RE: Timber Clad structure at Harefield Hospital - Ref: 9011/APP/2018/18541 message

Retention of hospital waste store (Retrospective Application) with new boundary hedge planting.

W West Elevation as Proposed
PL-003 SCALE: 1:50 @ A1

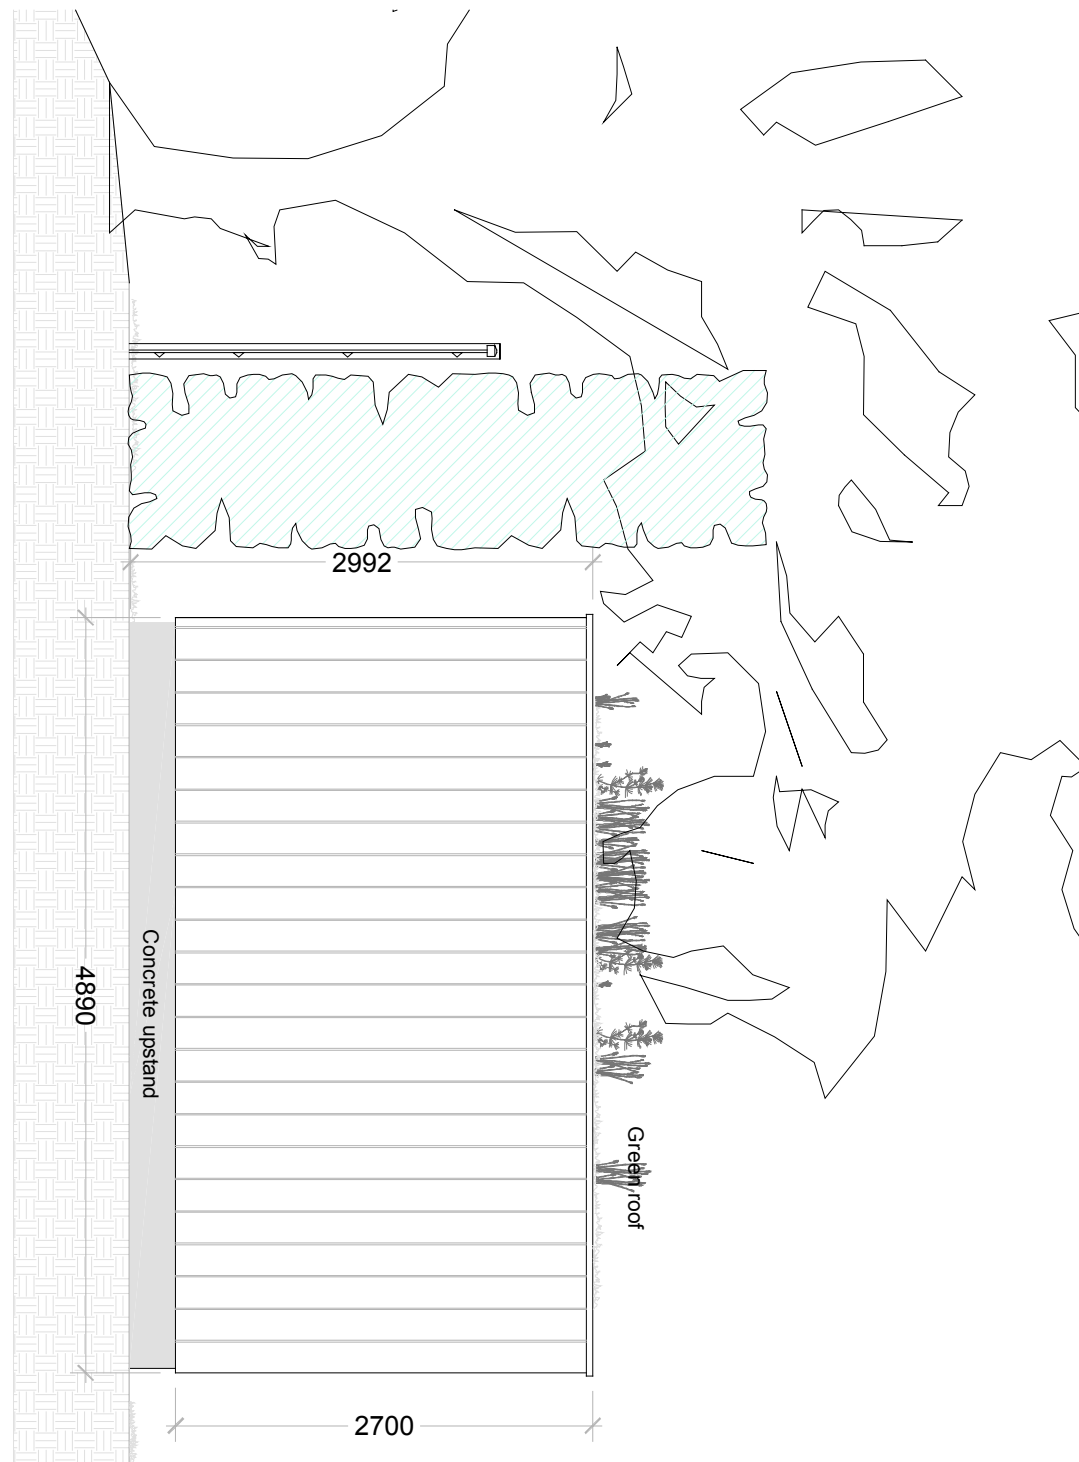
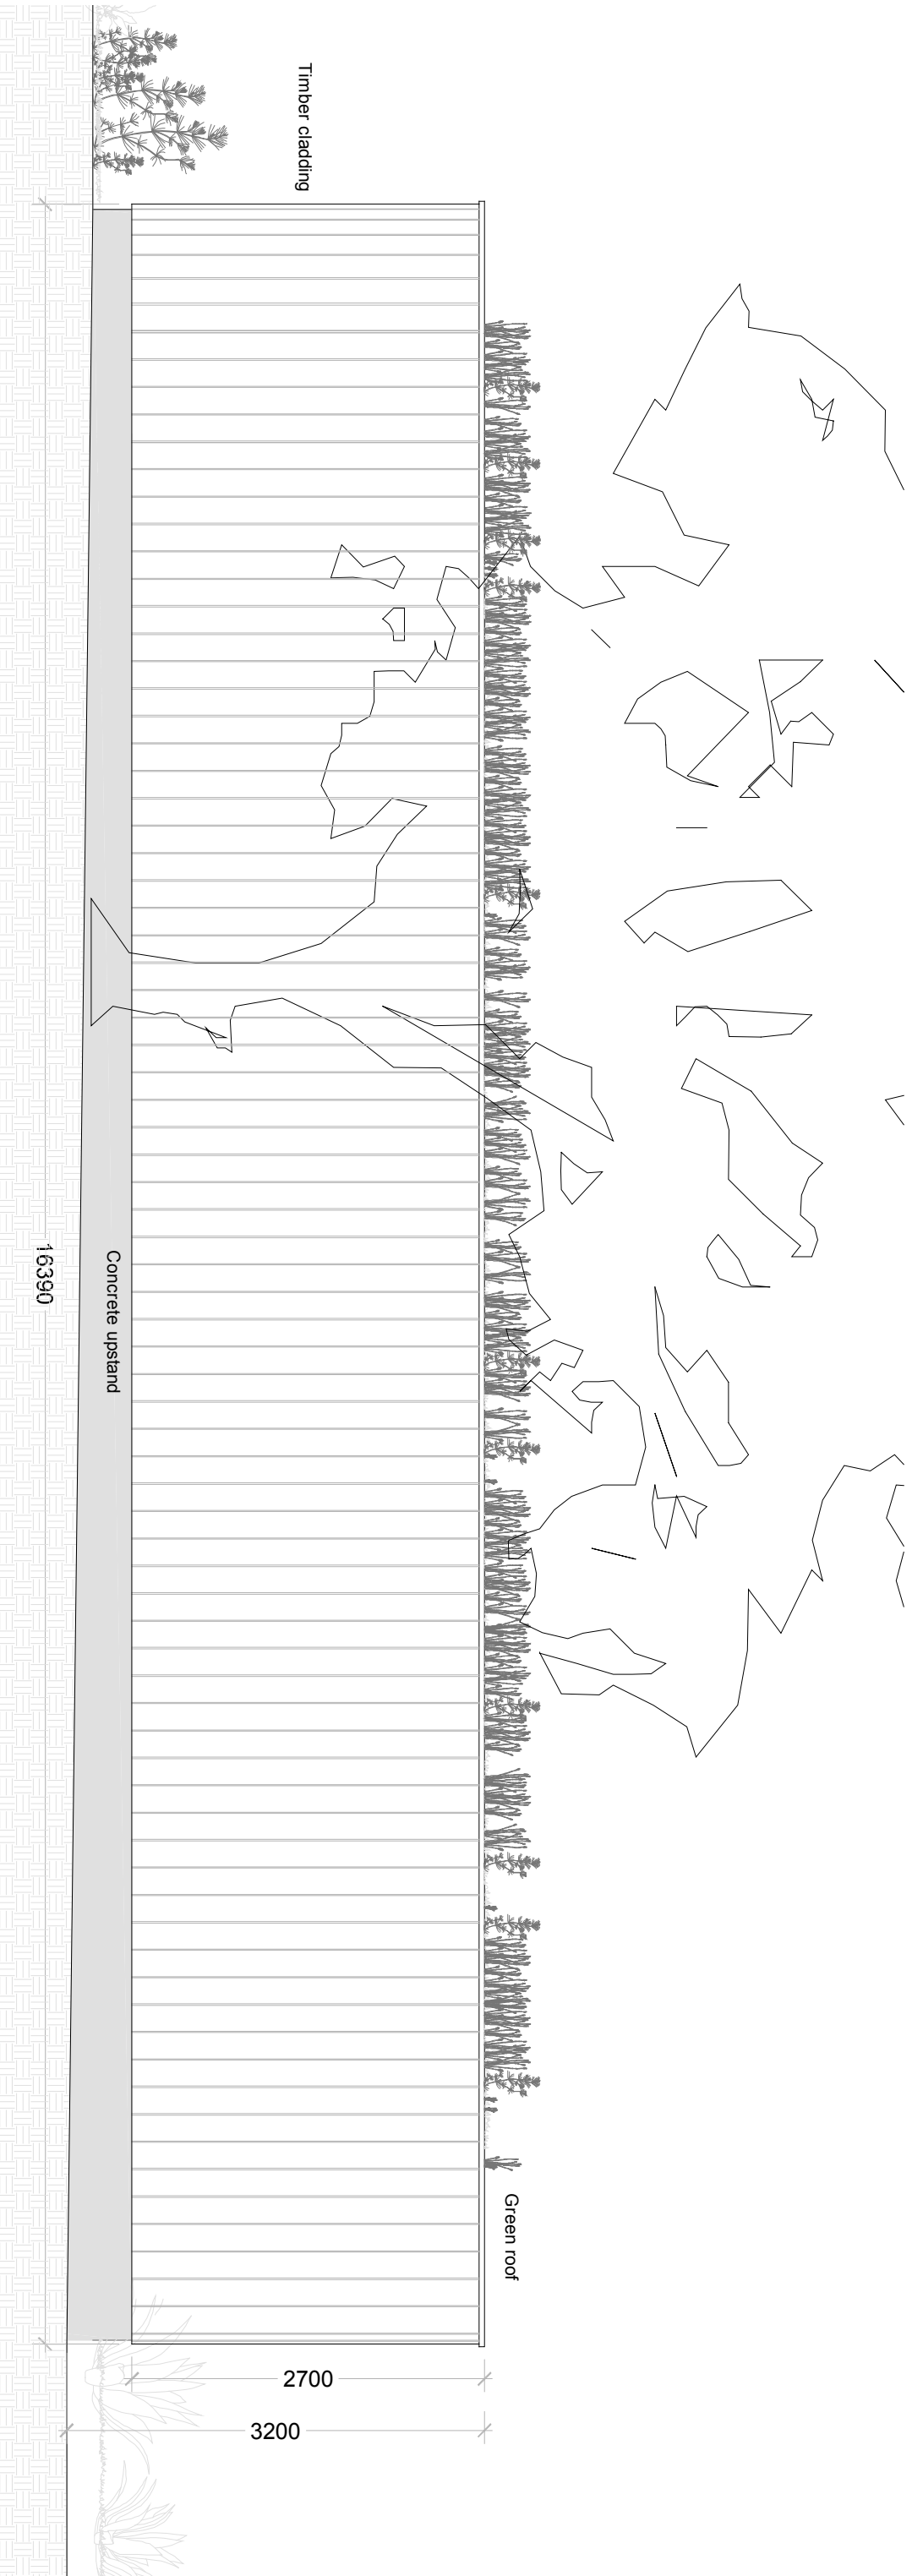
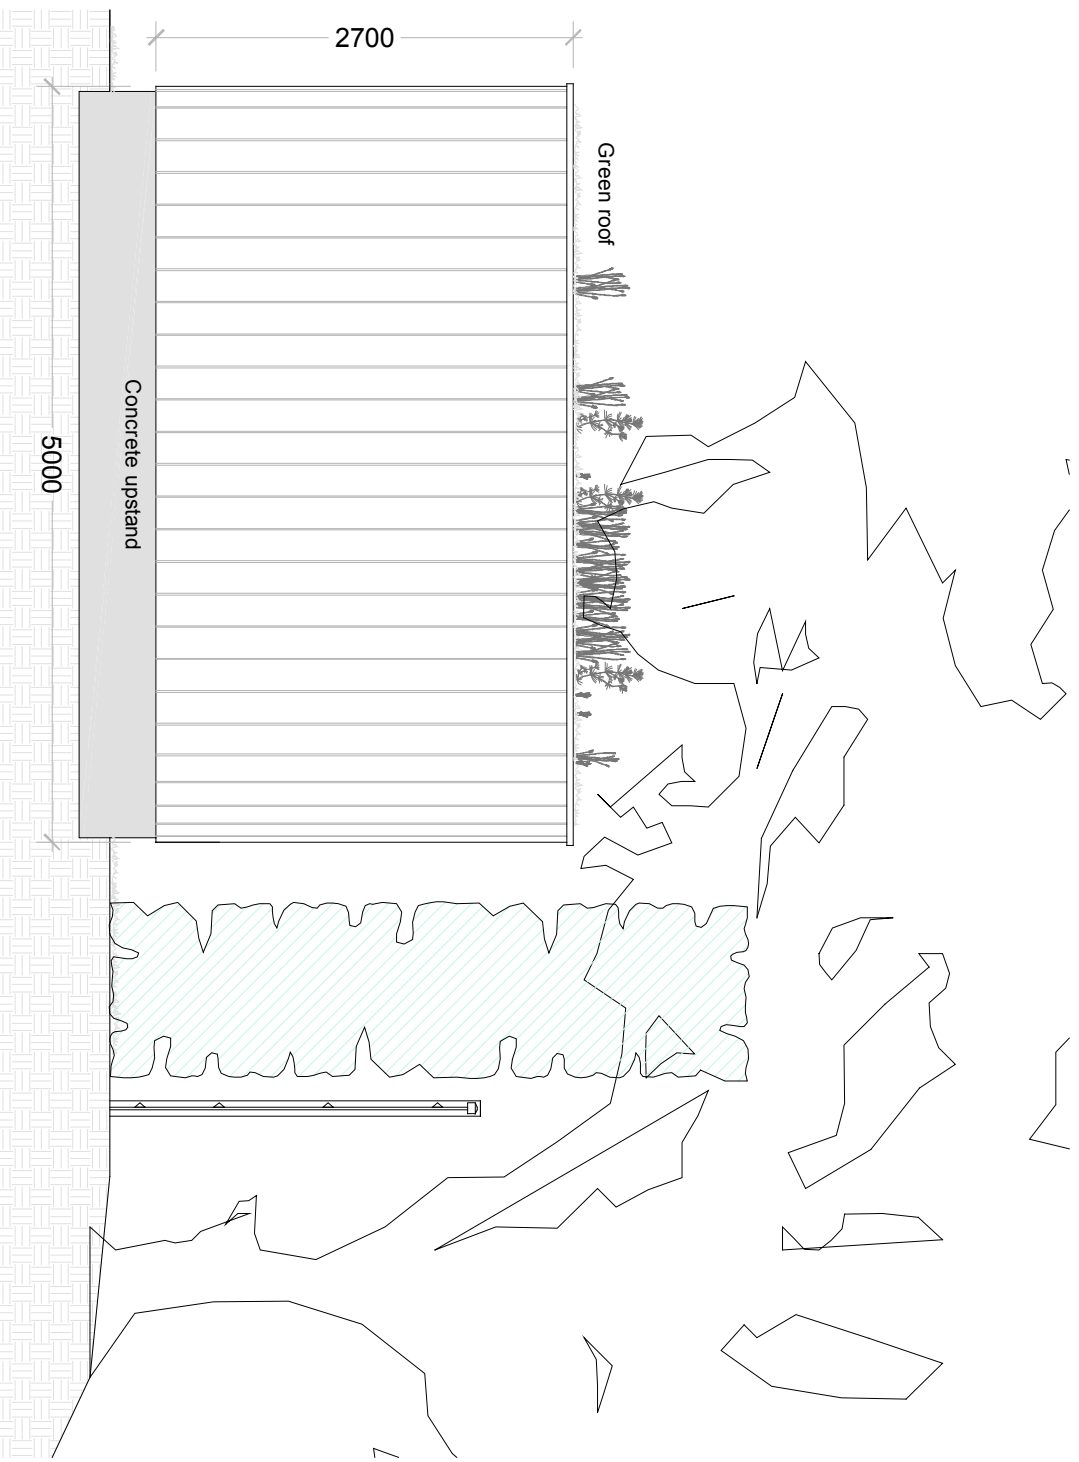
Council under 9011/APP/2015/3508. To this end, the West Elevation height measurement on approved plan stated 2.850m. This was measured at approx 3.2m this morning. There was other minor variations on the height of the structure. The length of the structure on previously approved plans was shown at 14.660m. This was measured on site at approx. 16.35m. The width of the structure as previously approved was 4.2m and this was measured on site at approx 5.0m. Can you please ensure that the planning application accurately reflects the development that has been constructed on site.
